Online Comment

Application H11-0866-26
Location 36 MARKET STREET LONG SUTTON SPALDING PE12 9DF
Proposal Conversion of detached garage into ancillary annexe for use by family member

Name Gregory Watkinson, Principal Conservation Officer
Address Council Offices Priory Road Spalding PE11 2XE

Date Submitted 14-10-26
For/Against Comments

PROPOSED FRONT
ELEVATION (SOUTH
WEST) 1:100

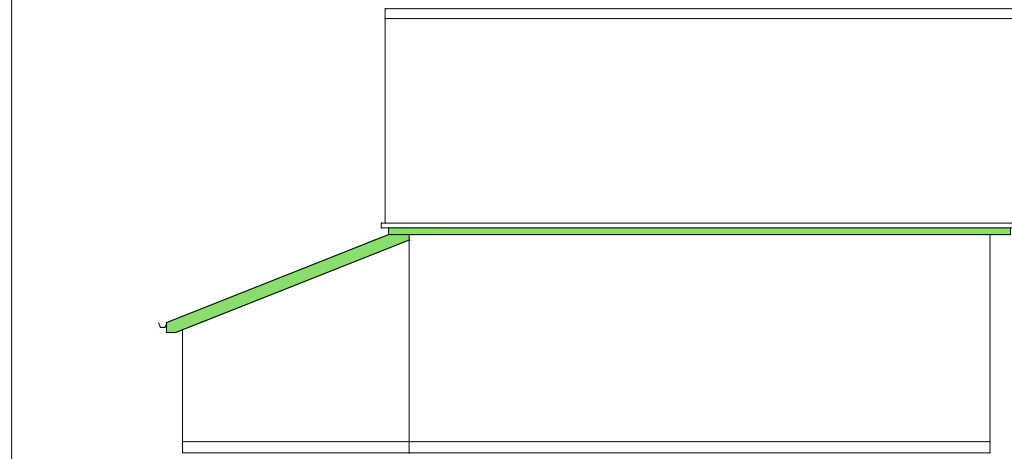
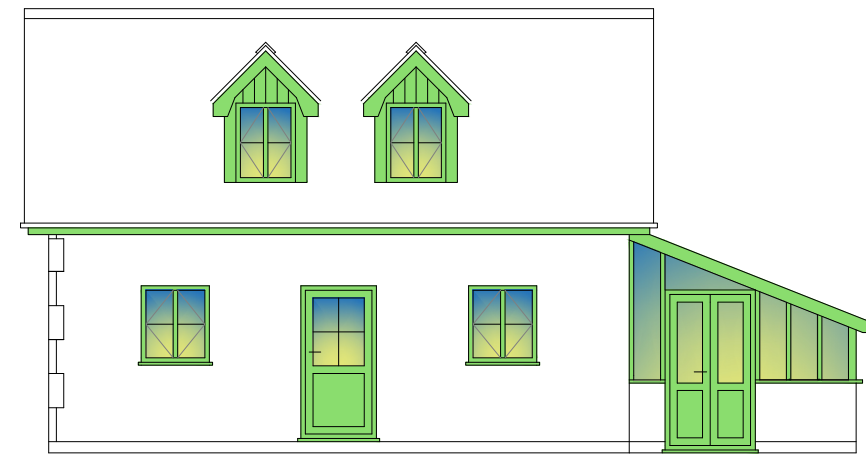
The application only proposes external alterations to the soffits and fascias, doors and fenestration, all proposed to use timber and of a closely matching style.

Consequently, I may only conclude that this development should bear no significant material effect upon the Conservation Area nor the adjacent listed building.
